**WELWYN HATFIELD BOROUGH COUNCIL
EXECUTIVE DIRECTOR - PLANNING, PUBLIC PROTECTION AND GOVERNANCE**

Application No: 6/2019/0102/PN8
Location: 3 Holme Close Hatfield AL10 9LQ
Proposal: Prior approval for the erection of a single storey rear extension measuring 6m in depth, 3.1m in height and 3m to the eaves
Officer: Ms Emily Stainer

Recommendation: Refused

Project title 3 Holme Close, Hatfield, AL10 9LQ		Scale @ A3 1:500
Drawing title Block plan		Drawn SH Checked HP
Drawing no. 18168_02

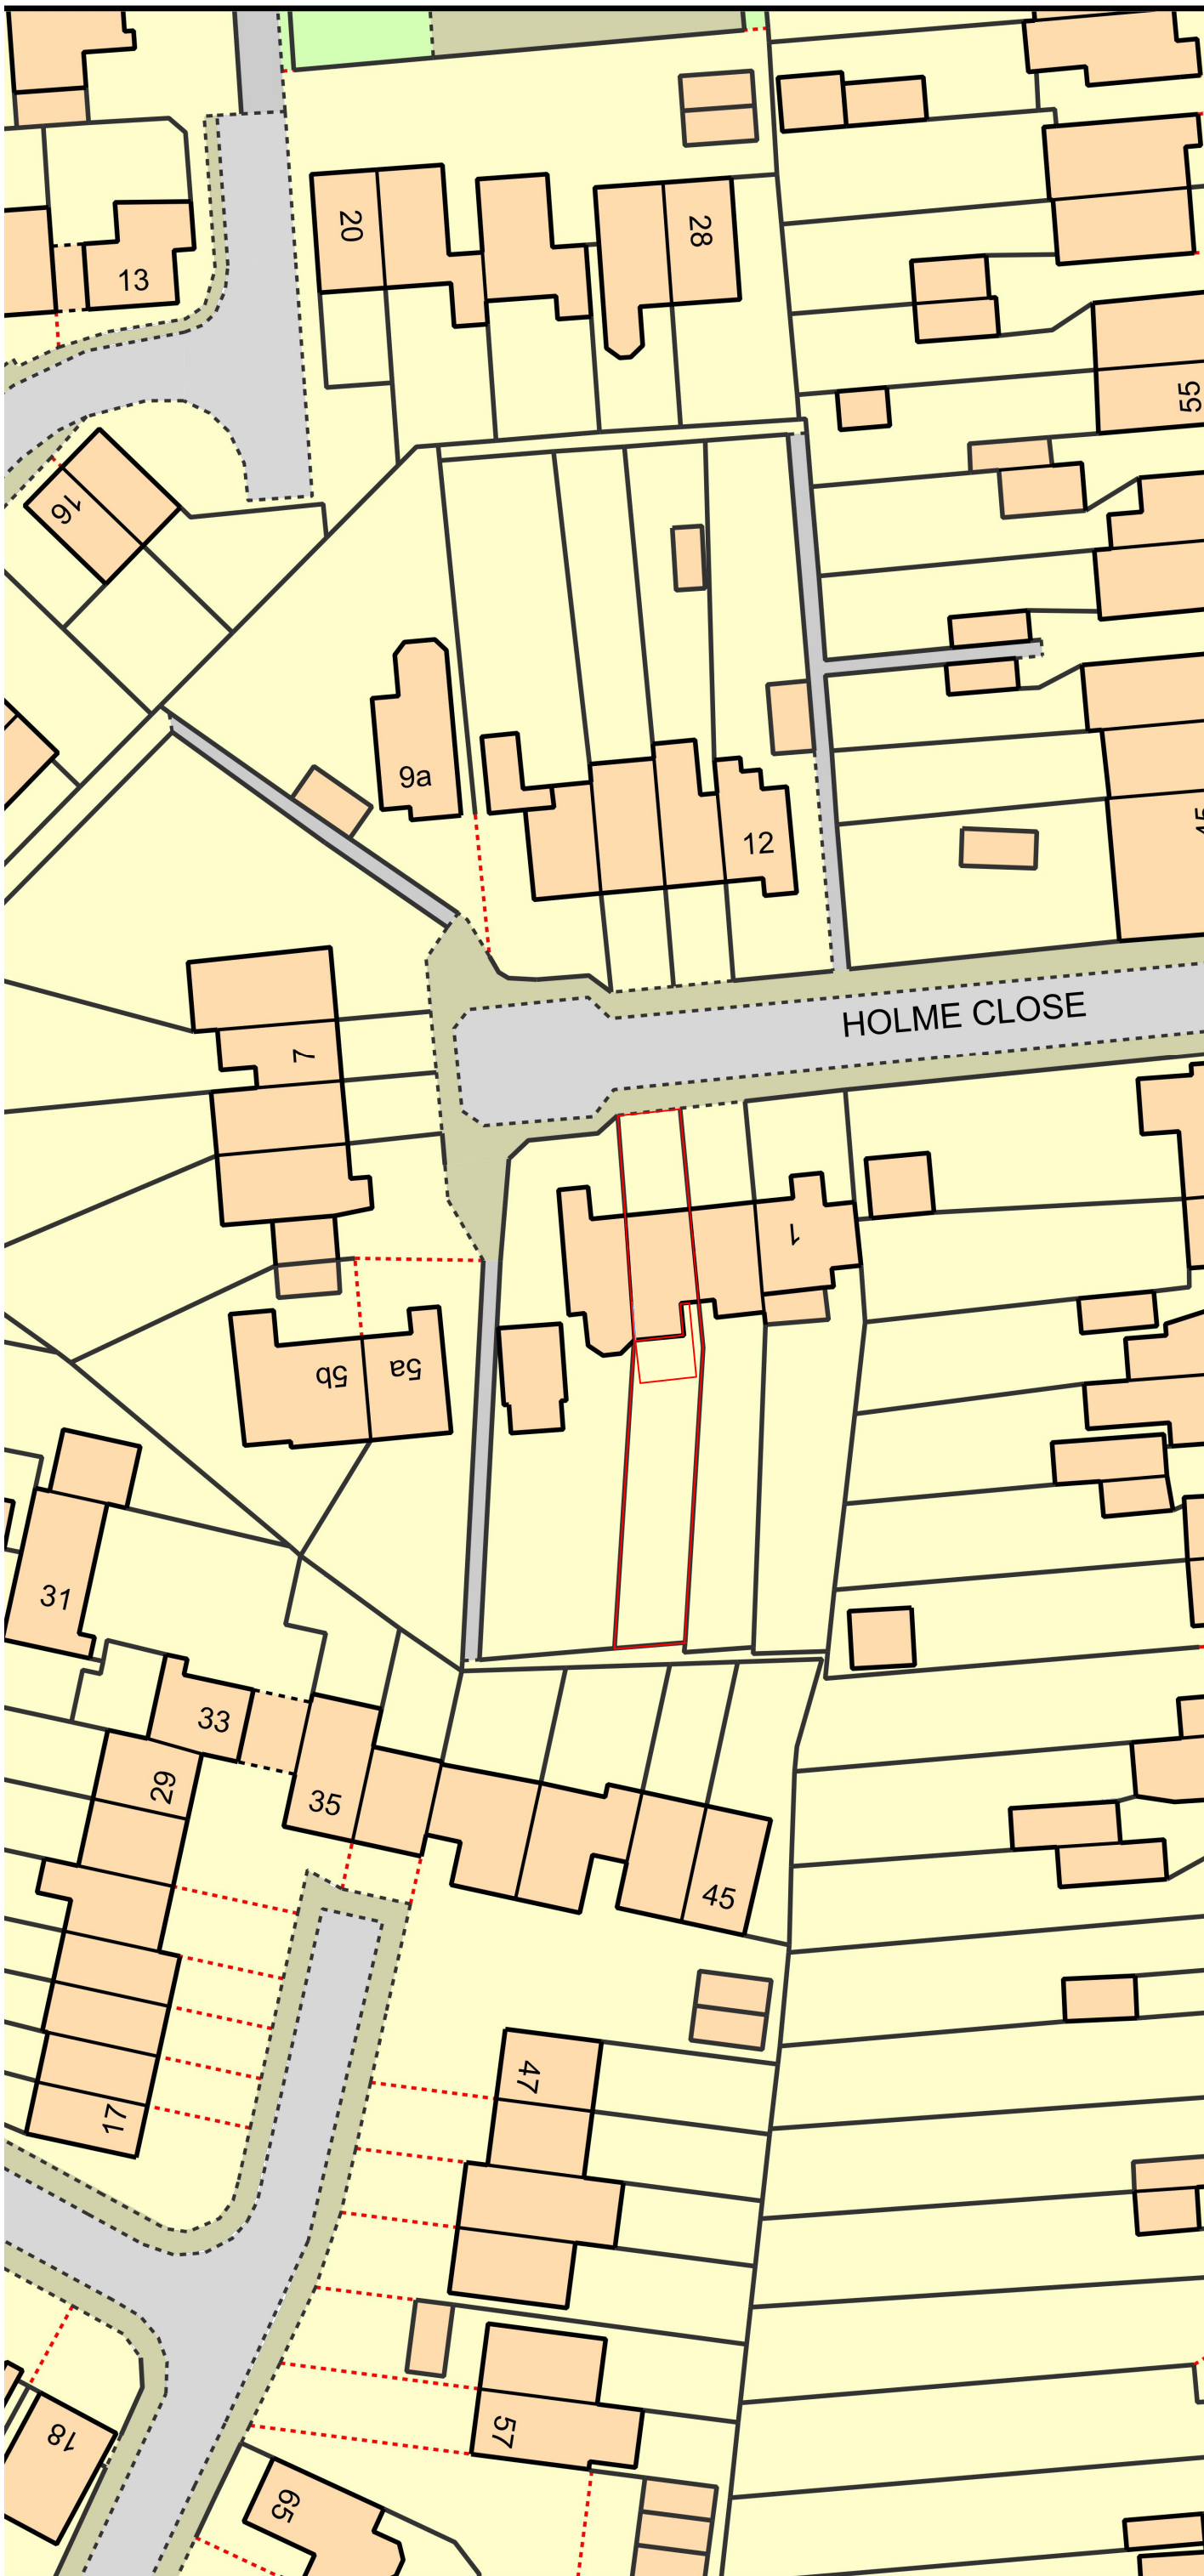
1. The proposed extension, by reason of its depth, height and siting, would appear unduly dominant and overbearing when viewed from No.2 and No.4 Holme Close and would result in a detrimental loss of daylight/sunlight to these properties. Consequently, the development would harm the living conditions of neighbouring occupiers to the detriment of their residential amenity.
